**EL PASO COUNTY PLANNING AND  
 COMMUNITY DEVELOPMENT  
 DEPARTMENT**

**STORMWATER MANAGEMENT PLAN CHECKLIST**

Revised: July 2019

ELDORADO SPRINGS	DESIGNED BY: MGP	DRAWN BY: MGP
GRADING & EROSION CONTROL PLAN	SCALE: 1"=30'	DATE: 10/07/20
	JOB NUMBER	SHEET
	91807	GR2 OF 10

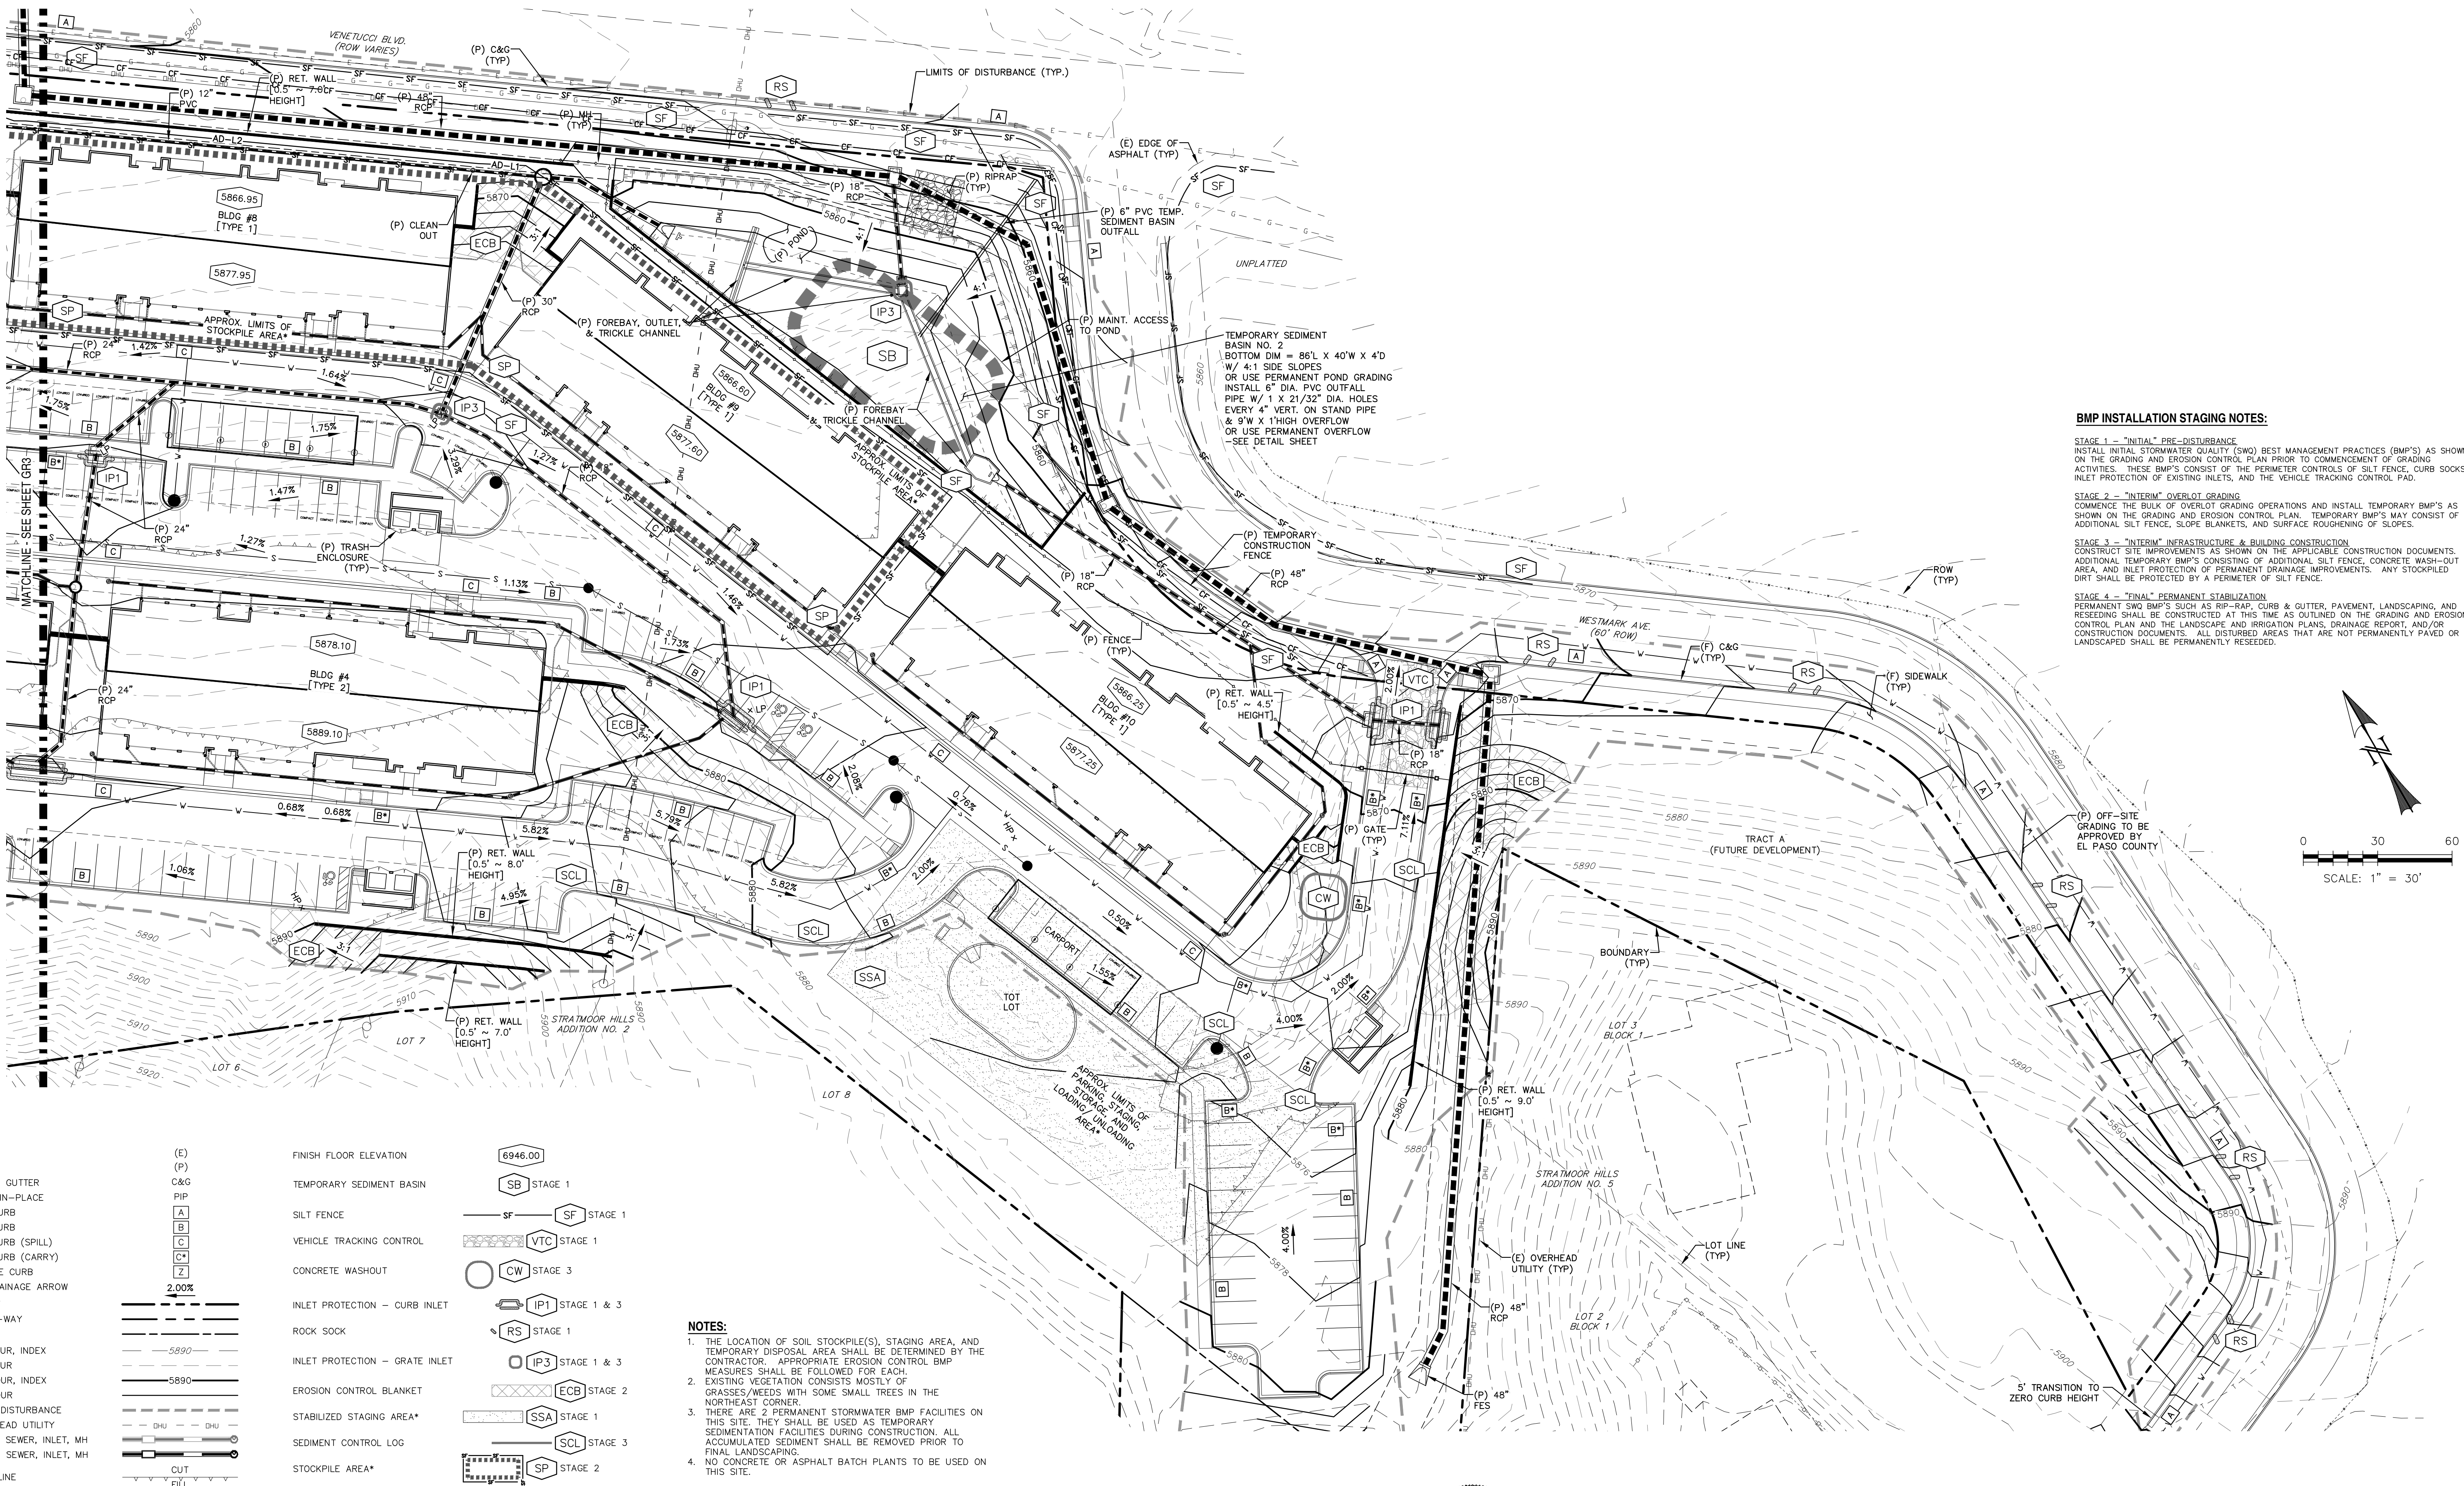
Applicant	PCD
<b>1. STORMWATER MANAGEMENT PLAN</b>			
Info added to cover			
1	Applicant (owner/designated operator), SWMP Preparer, Qualified Stormwater Manager, and Contractor Information. (On cover/title sheet)	X	X
2	Table of Contents	X	✓
3	Site description and location to include: vicinity map with nearest street/crossroads description.	X	✓
4	Narrative description of the project, including, temporary and permanent impacts, and a plan to be used to document changes mentioned in text on Page 12.	X	✓
5	Phase I and II stormwater management projects. Provide "flexibility" that can be revised in the field as conditions dictate.	N/A	X
6	Proposed schedule of construction completion: Provide a construction schedule of anticipated starting and completion dates; Provide a construction schedule of anticipated starting and completion dates depicting conservation measures anticipated, including the expected date on which the final stabilization will be completed.	X	X

Revised: July 2019		Applicant	PCD
17	SWMP Map to include:		
17a	construction site boundaries	X	✓
17b	flow arrows to depict	X	X
17c	all areas of disturbance	X	✓
17d	areas of cut and fill	X	✓
17e	areas used for storage (skips) or wastes	X	✓
17f	location of any	N/A	X
17g	location of all structural control measures	X	✓
17h	location of all non-structural control measures	X	✓
17i	springs, streams, wetlands and other surface waters, including areas that require maintenance of pre-existing vegetation within 50 feet of a receiving water	N/A	✓
18	Narrative description of all structural control measures to be used. Modifications to EPC standard control measures must meet or exceed County-approved details.	X	✓
19	Description of all existing vegetation to be protected, including, protection of	X	✓
20	Technical drawing details used must meet or exceed EPC standards	X	X
21	Procedure describing how the SWMP is to be revised	X	✓

GEC plans now show phasing element to BMPs. On-site GEC plan to be used to document changes mentioned in text on Page 12.

Grade arrows shown on plan. added to legend.

Note added to plan - no batch plants.
